Project Name: AMERICAN SQUARE

DATE: May 17, 2013
TO: Jack Cloud, DRB Chair
FROM: Catalina Lehner, Senior Planner *CLL*
RE: Project #1008124, Murphy Oil- American Square SC
Site Development Plan for Subdivision Amendment and
Site Development Plan for Building Permit

Staff reviewed the April 18, 2013 version of the site development plans and finds the following regarding the site development plan for building permit:

SITE PLAN FOR BUILDING PERMIT LOT 1, BLOCK A-1-A1, AMERICAN SQUARE

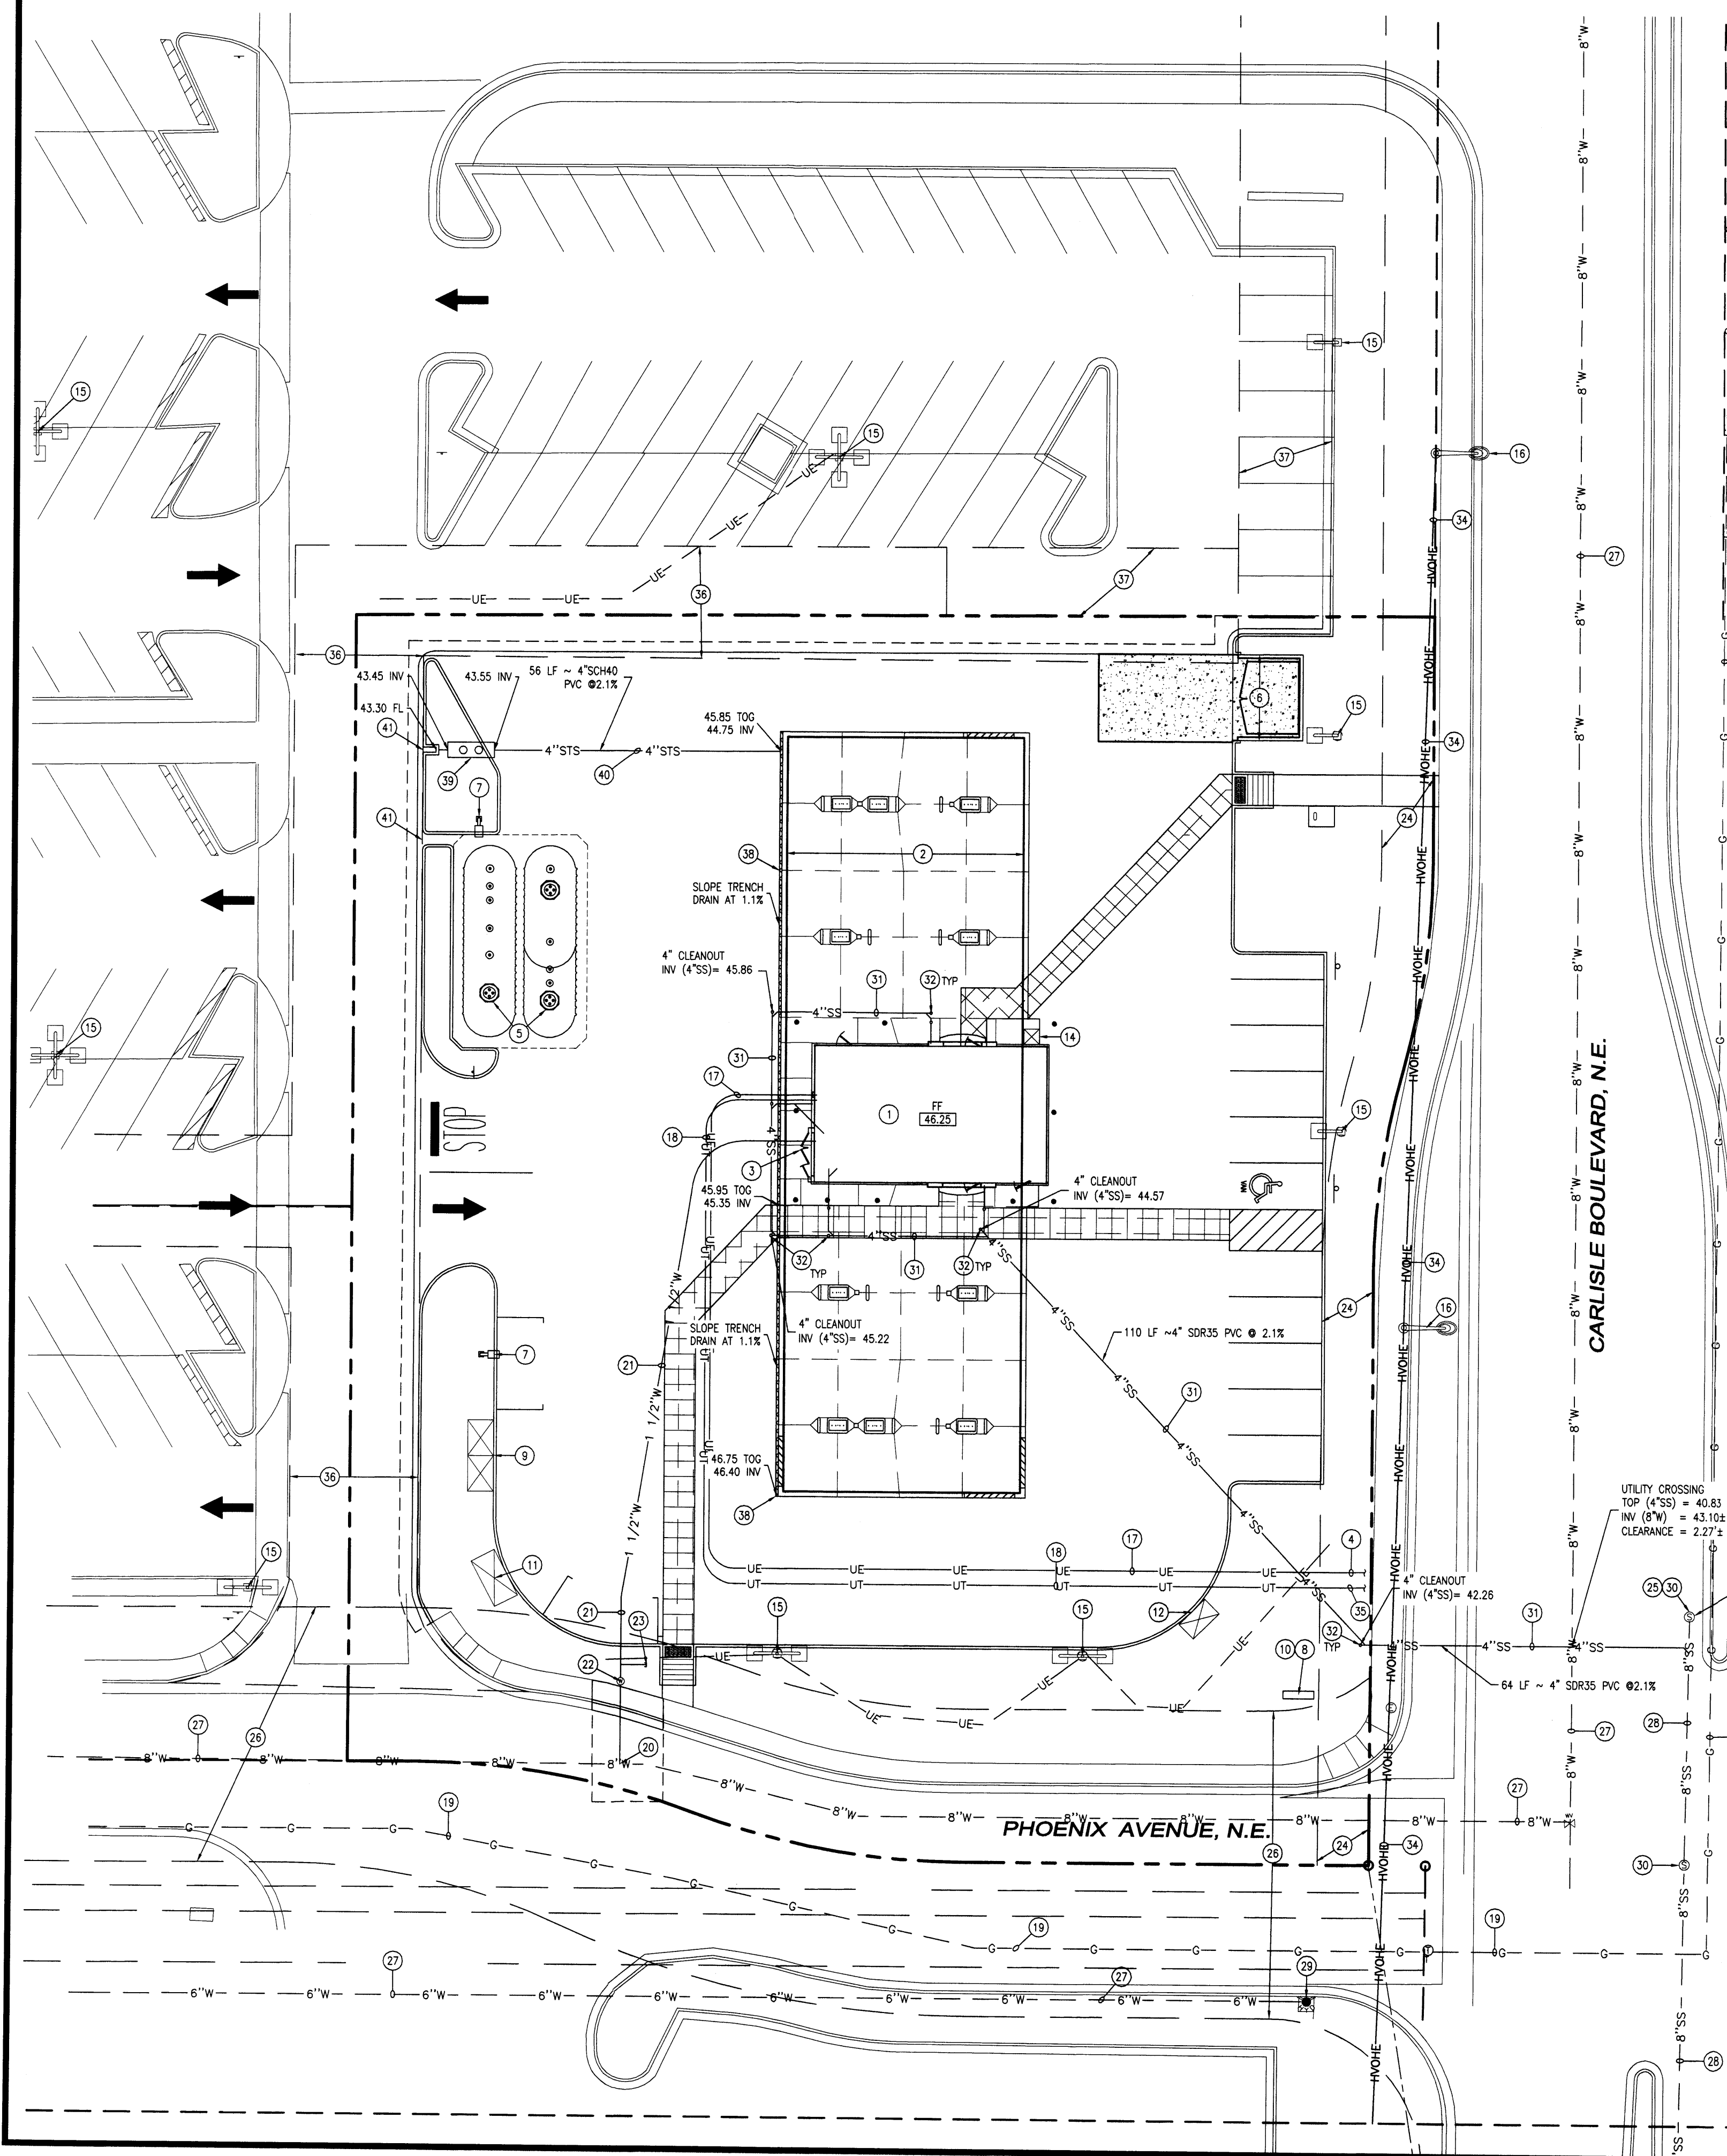
Condition 10: The pedestrian connection across the landscape buffer, leading from the building's southern entrance to Carlisle Blvd., was not shown.

UTILITY PLAN

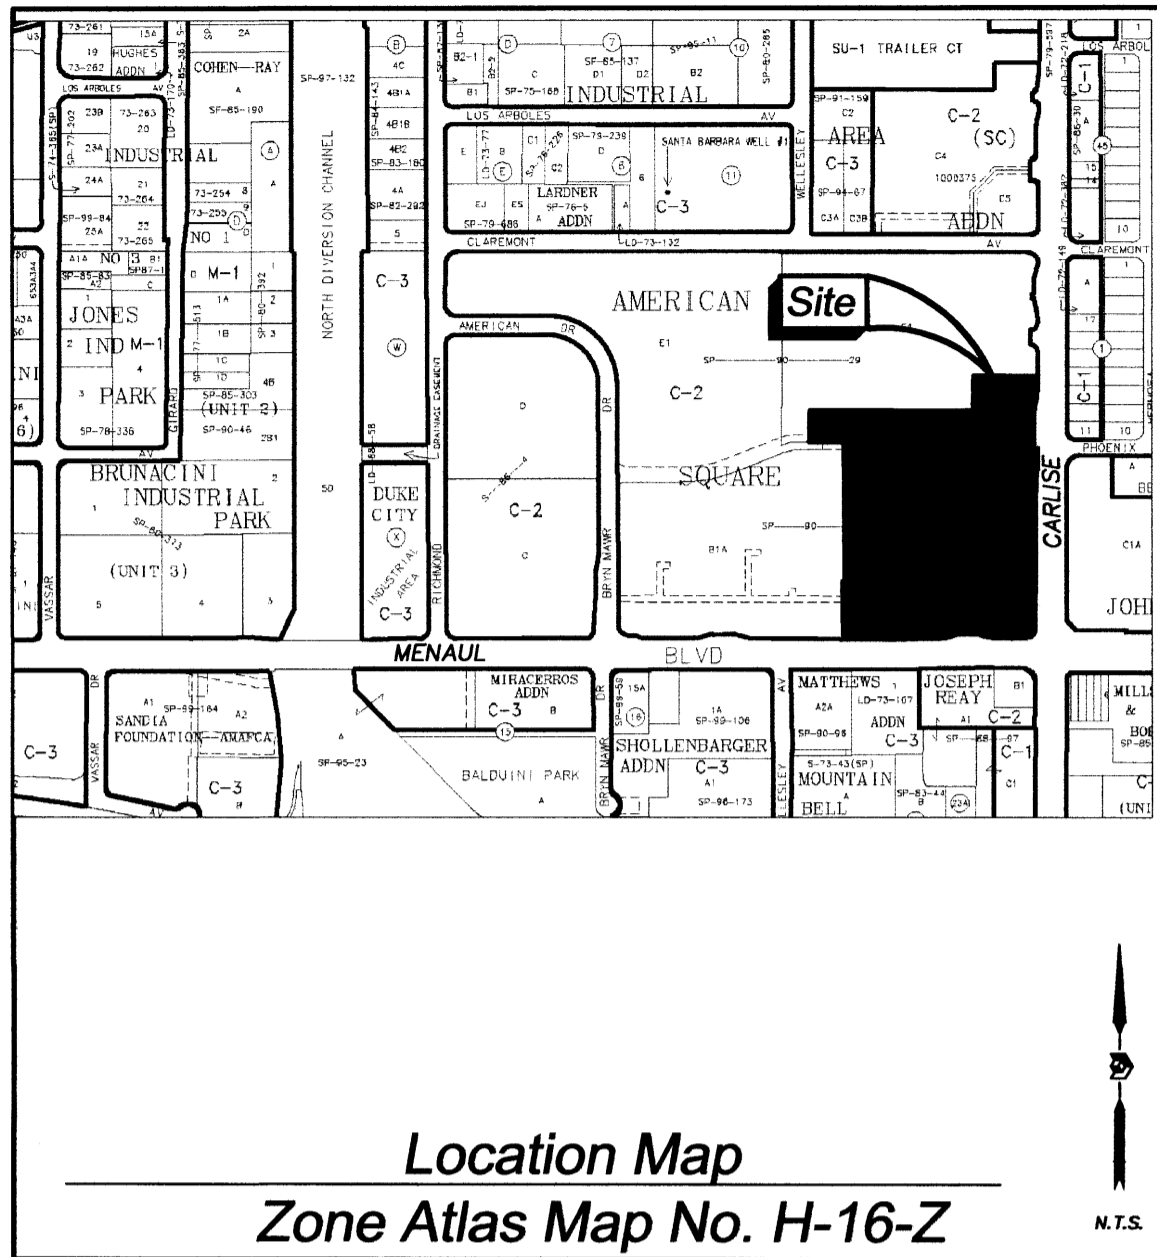
The utility plan was not provided with the DRB site development plan set. However, Bryan Reid has indicated that it will be provided (and switched out?)
